**EL PASO COUNTY**

**Subject: Forest Lakes Filing No. 6 Final Plat, Preliminary Comments (SF-20-027)**

### Forest Lakes Filing No. 6 Final Plat Development Application Review

FOREST LAKES FILING NO. 6
RECEPTION NO. 220714540
COUNTY ZONING: PUD

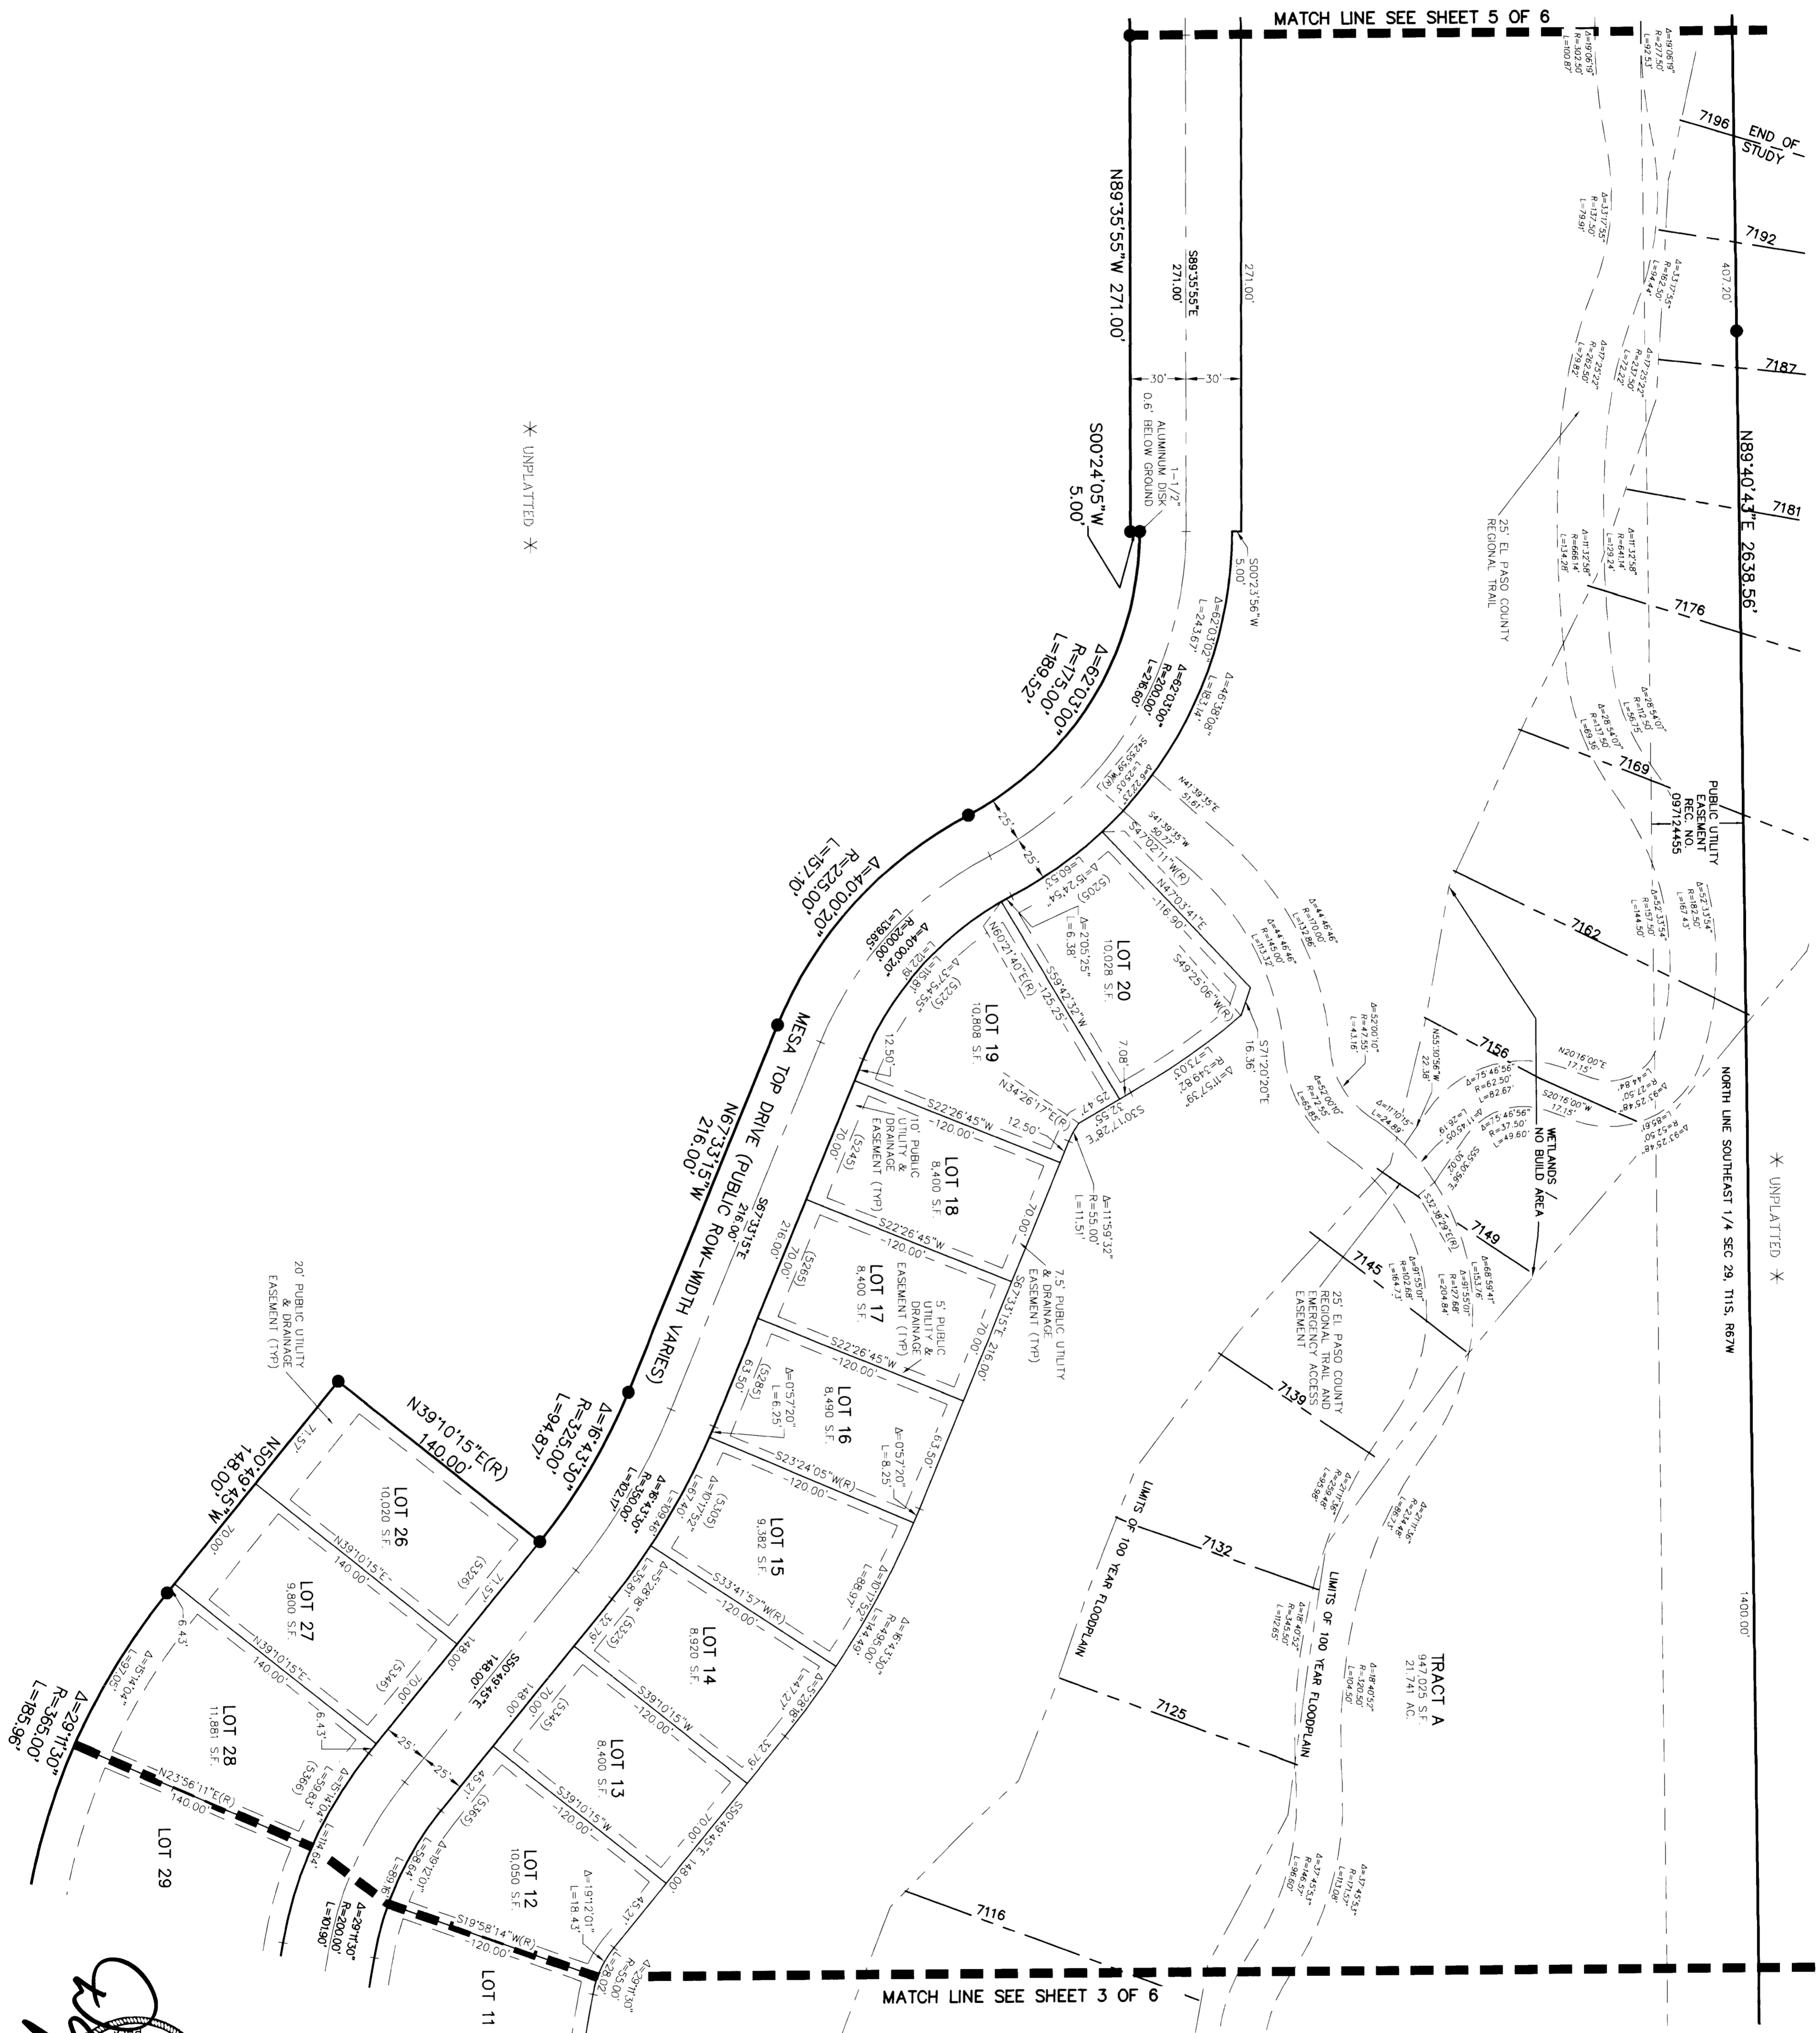
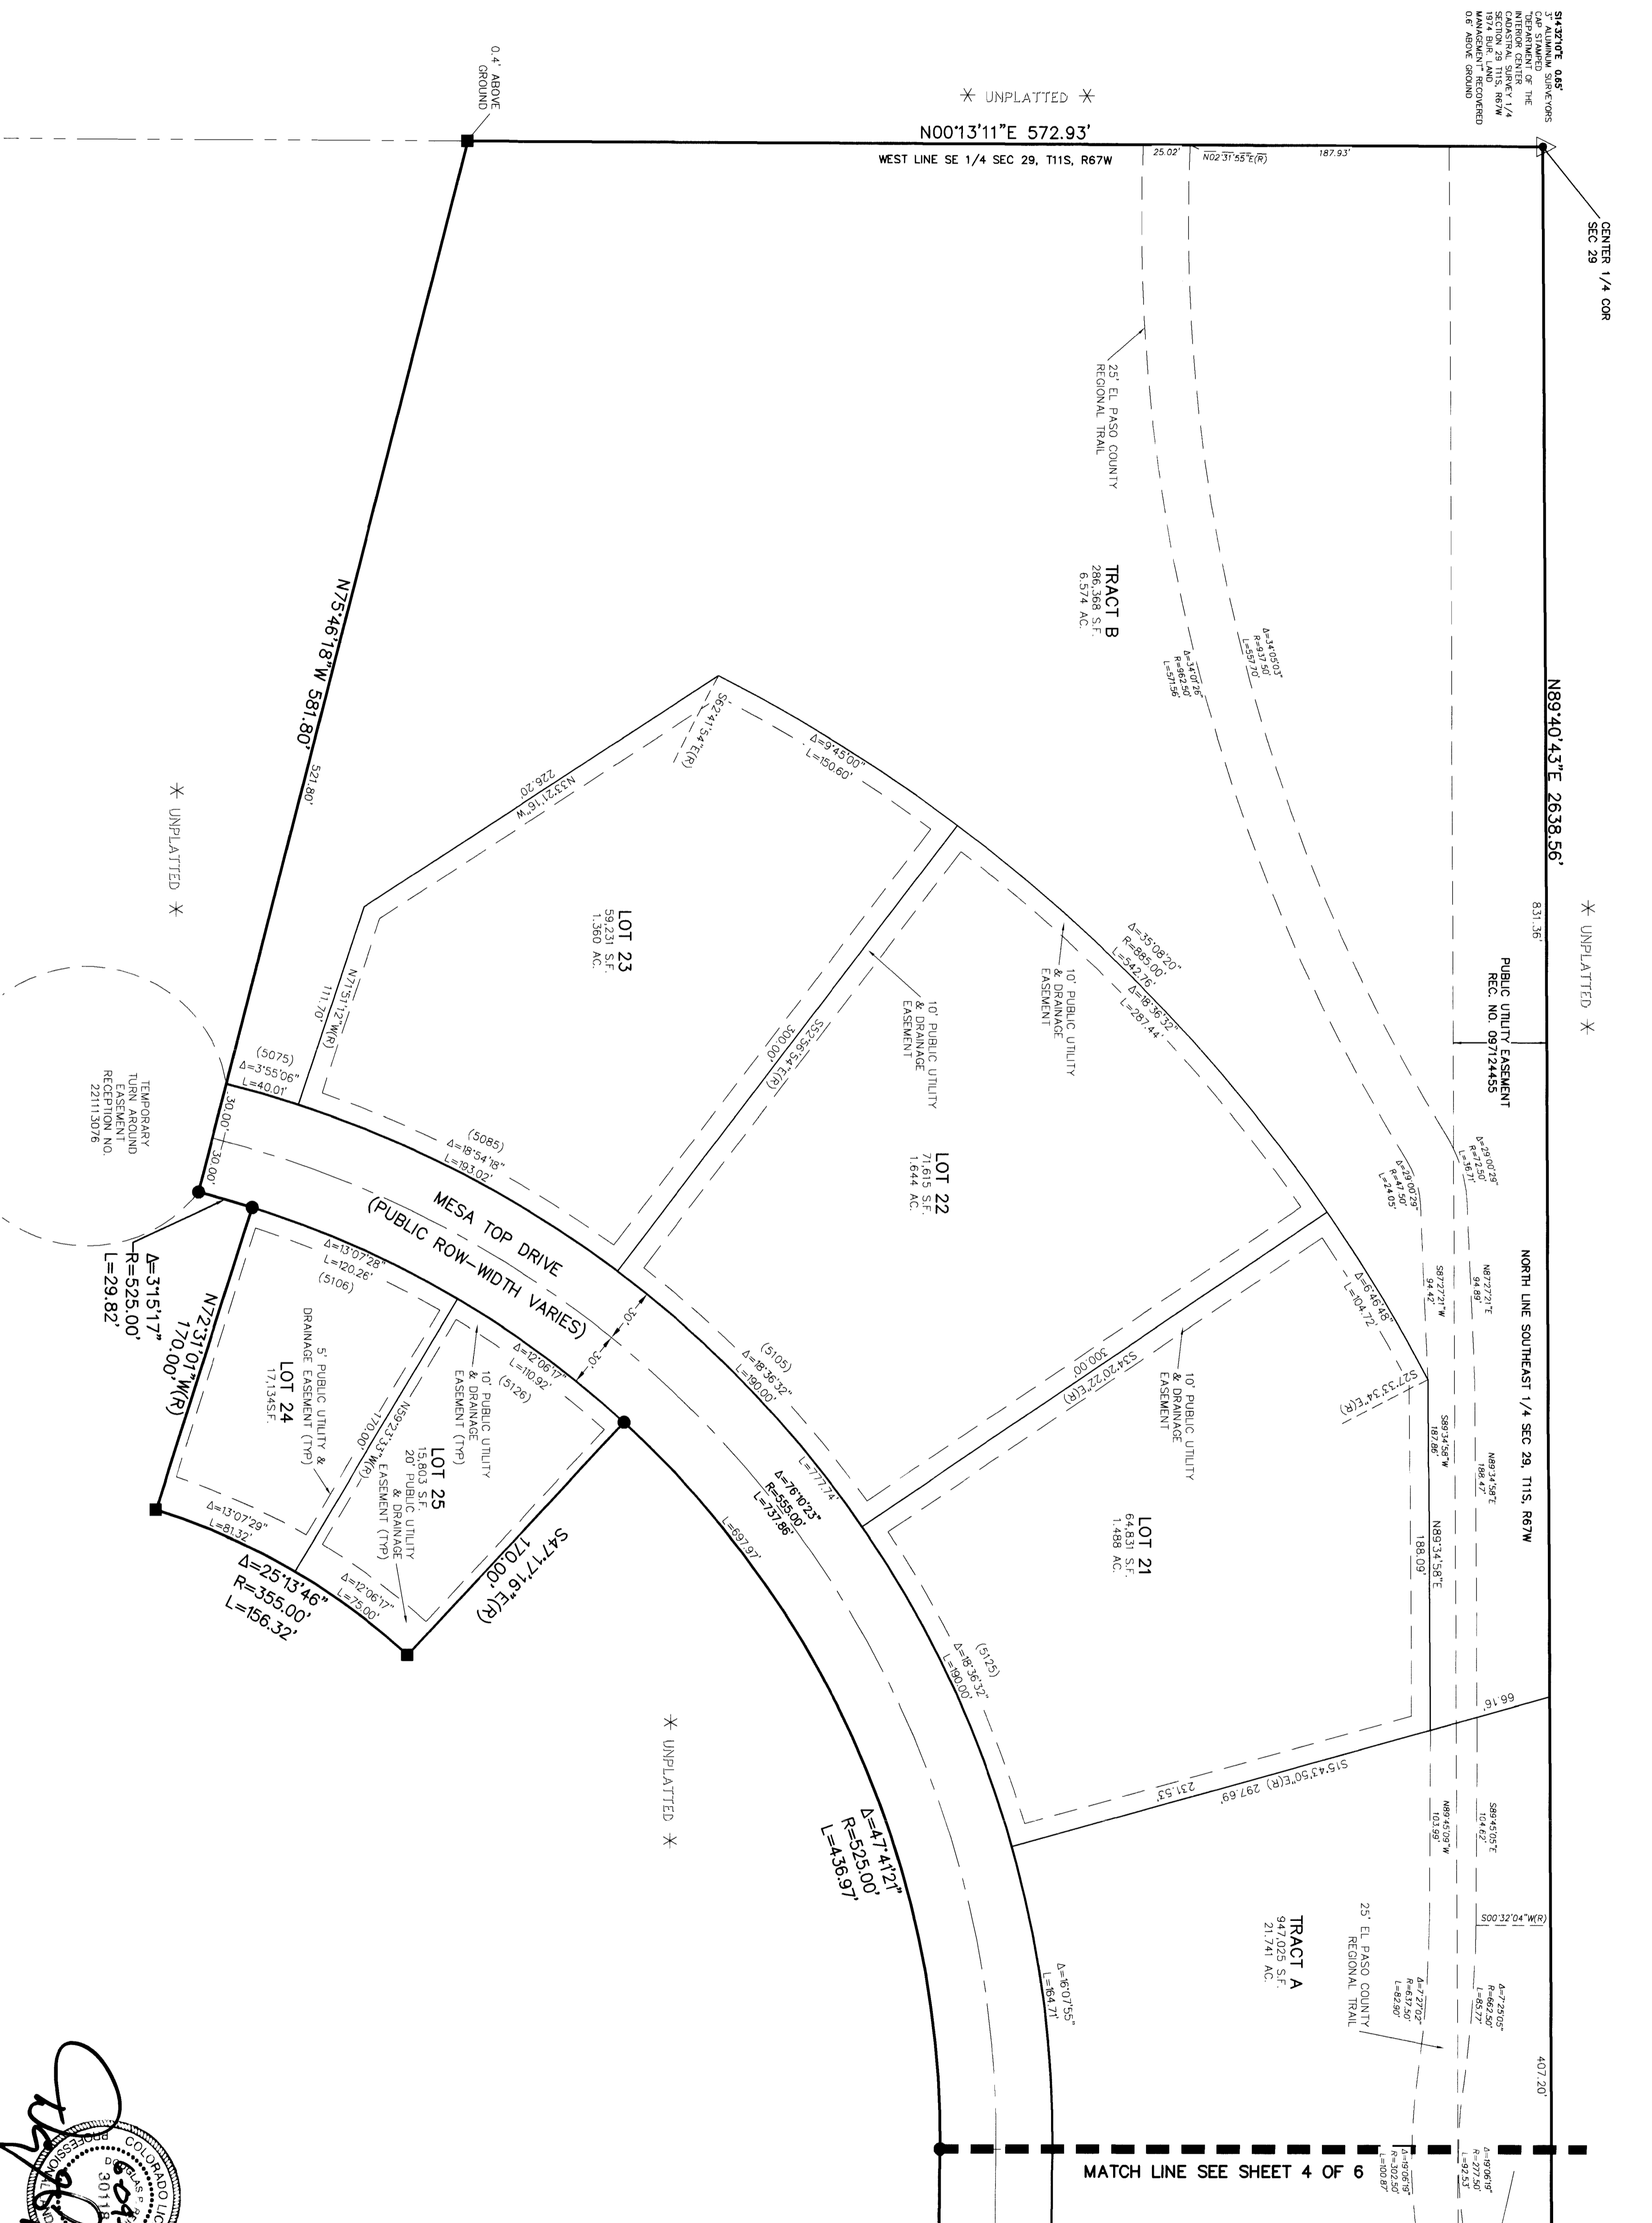
The BoCC-approved Forest Lakes Phase II PUD Preliminary Plan shows in detail the Forest Lakes Secondary Regional Trail, as well as the internal trail network and emergency access road. However, the Forest Lakes Filing No. 6 Final Plat does not show the 25-foot trail easement through the project site, and the Final Plat notes do not reference the dedication of the trail easement to El Paso County. As such, staff recommends that the applicant include the easement alignment in the Final Plat drawings and include language in the Final Plat General Notes that designates and provides to El Paso County a 25-foot trail easement through Forest Lakes Filing No. 6, within Tracts A and B, that allows for public access of the Forest Lakes Secondary Regional Trail, and dedicate the aforementioned easement to El Paso County prior to the recording of the Final Plat.

*The Park Advisory Board recommends that the Planning Commission and the Board of County Commissioners include the following conditions when considering and/or approving the Forest Lakes Filing No. 6 Final Plat: (1) designate and provide to El Paso County a 25-foot trail easement through Forest Lakes Filing No. 6 Final Plat, within Tracts A and B, that allows for public access of the Forest Lakes Secondary Regional Trail, and dedicate the easement to El Paso County within the Final Plat General Notes prior to the recording of the Final Plat; (2) regional park fees are not required pursuant to the existing Forest Lakes Phase I PUD Preliminary Plan and Filing No. 1 Final Plat recommended and endorsed motions; (3) the section of the Forest Lakes Secondary Regional Trail located within Filing No. 6 shall be constructed within two years of the recording of the Final Plat; (4) trail plans shall be submitted to and approved by County Parks prior to construction; (5) the trail shall be constructed to Tier 1 standards for a regional trail; (6) the trail shall be maintained by the Forest Lakes Metropolitan District when contained within developer-owned tracts, while El Paso County agrees to maintain the Regional Trail when contained within dedicated roadway rights-of-way; (7) require fees in lieu of land dedication for urban park purposes in the amount of \$20,060. A Park Lands Agreement may be an acceptable alternative to urban park fees, provided the agreement is approved by the County and executed prior to recording the Final Plat.*
